REQUEST

Current Zoning: N1-A (neighborhood 1-A)
Proposed Zoning: N2-A(CD) (neighborhood 2-A, conditional)

Approximately 9.24 acres located at the dead-end of Jenkins Avenue and along the west side of Wright Avenue.

The petition proposes to develop up to 93 single family attached residential homes on a vacant parcel located between Walker Road and Craig Avenue, north of Sharon Amity Road.

**RZ.01**

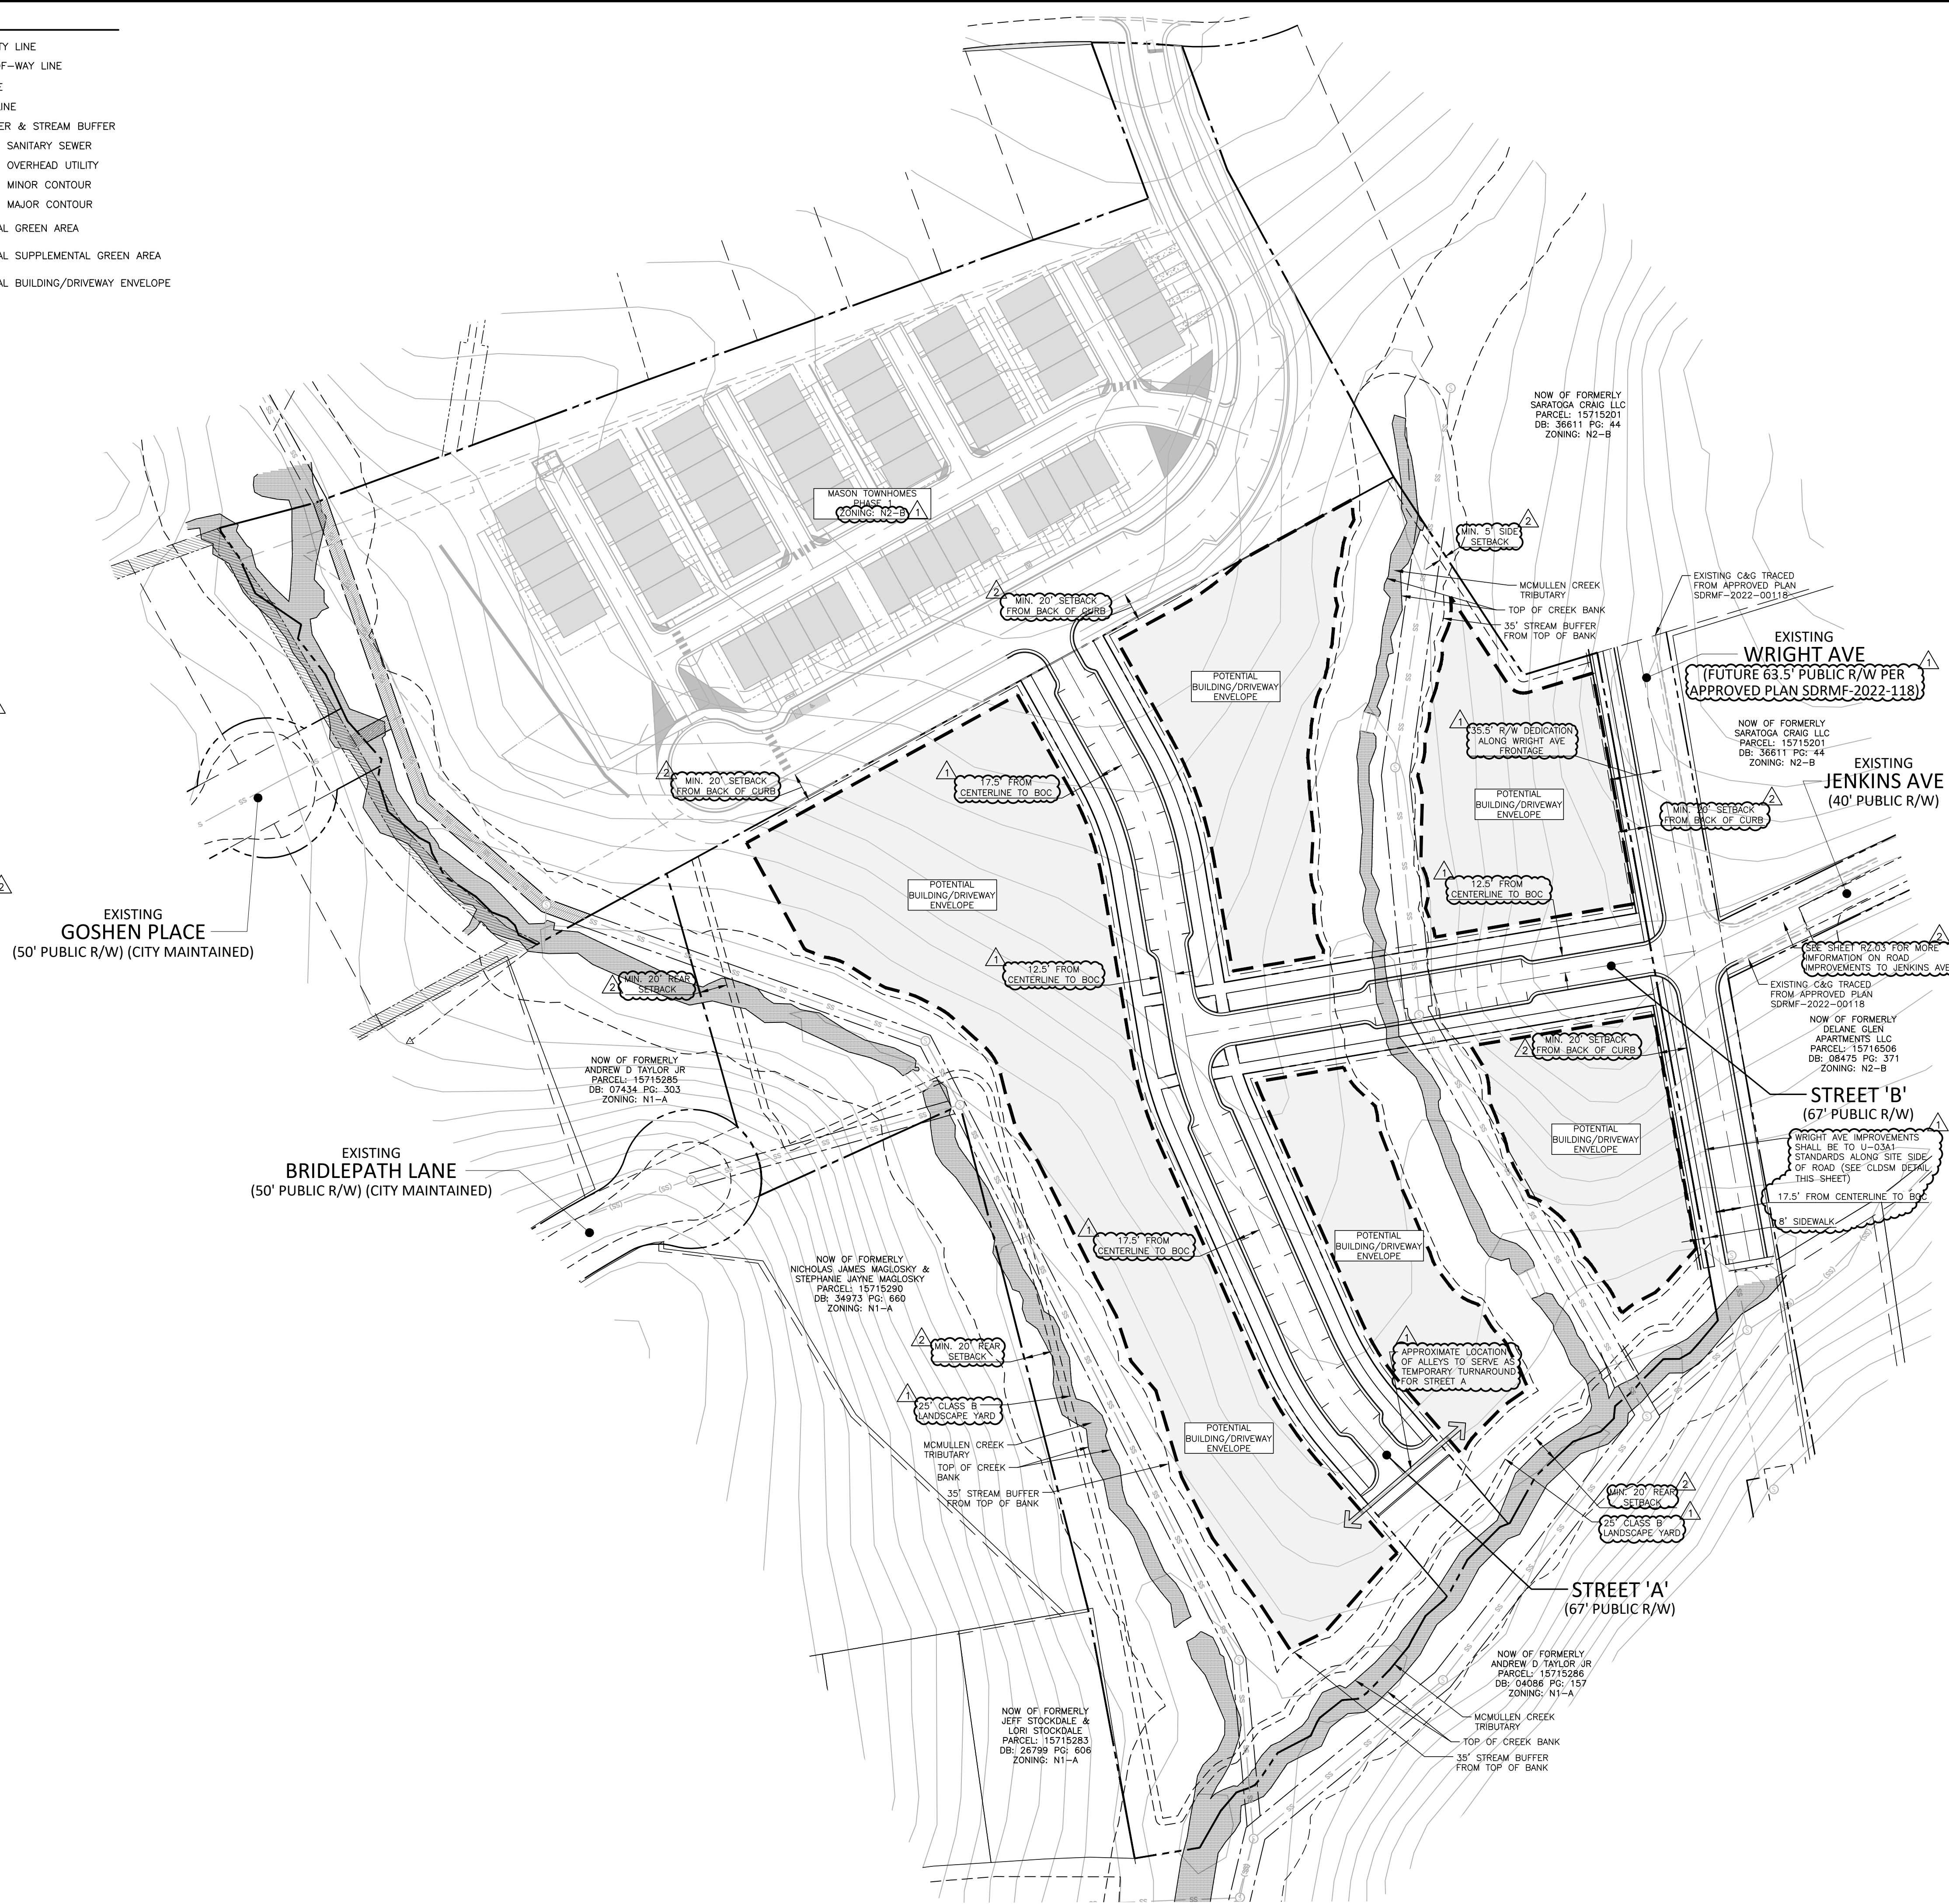
1. We recommend adding the following note under Environmental Features: "Petitioner agrees to provide 100-yr stormwater peak control or provide a downstream analysis using the criteria specified in the SCM Design Manual." **Not addressed**
2. Green area is broken up into too many sections (max of 3) Please review the Charlotte Tree Manual for guidance. **Update: Tree save areas are not shown on the site plan. Not addressed**
